Your Ref: OWPC21135
Our Ref: EP/179/18/PL 12-12-2018
Please ask for:
Mrs A Gardner

Demolition of existing house & erection of 3x 3 bedroom houses together with landscaping, car parking and fencing.

Gladwyn The Street East Preston

Thank you for your internet representation made on 16th January 2019 which has been recorded as '**an objection**' with the comments as follows:

Project: Proposed new homes; Gladwyn, The Street, East Preston BN16 1HT			
Drawing: Block plan			
FOR: Mrs. J. Simmonds & Mr. P. Beamish			
Drawn: PKS	Date: November 2018		
Scales: 1:200	No: 2386/01/03/A		
To scale when printed on A3

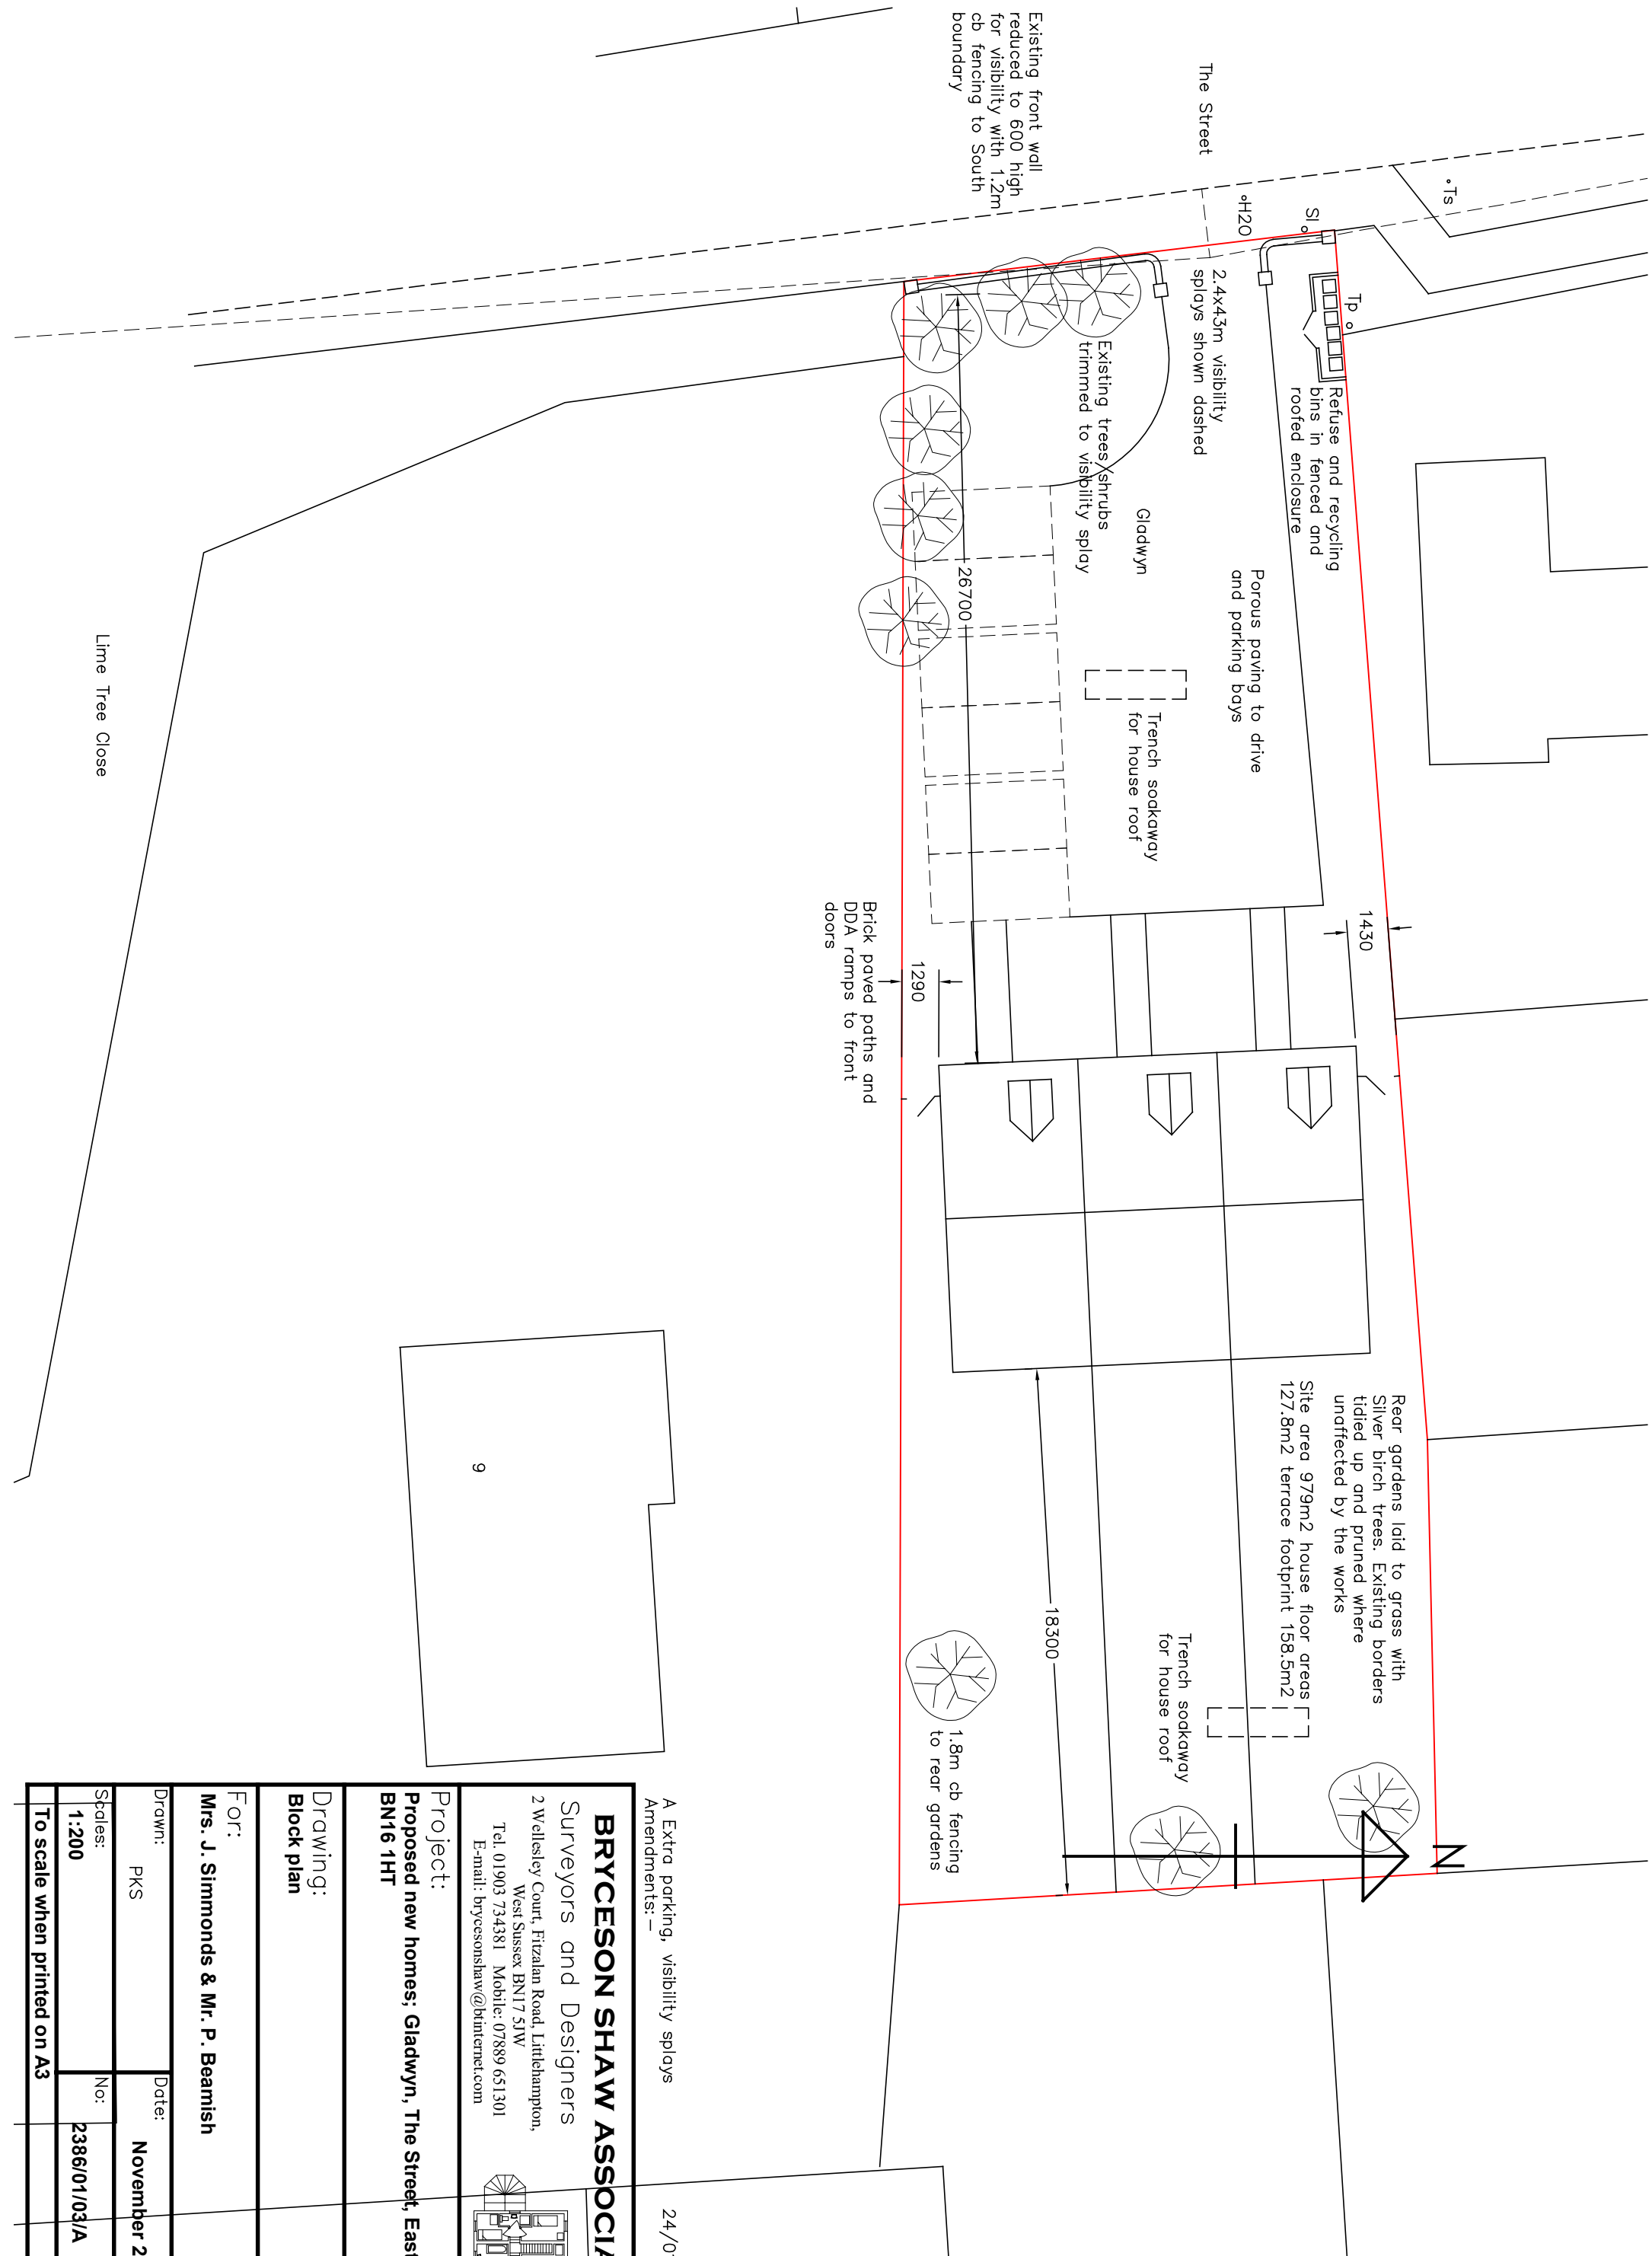
I have been unable to determine from the Block Plans provided whether the proposed properties would occupy the same footprint as the existing dwelling. It would be helpful if a plan was provided that illustrates the existing footprint overlaid with the proposed footprint. This would clarify whether the distance between the properties that share borders with the proposed development is to remain the same or whether this is set to reduce.
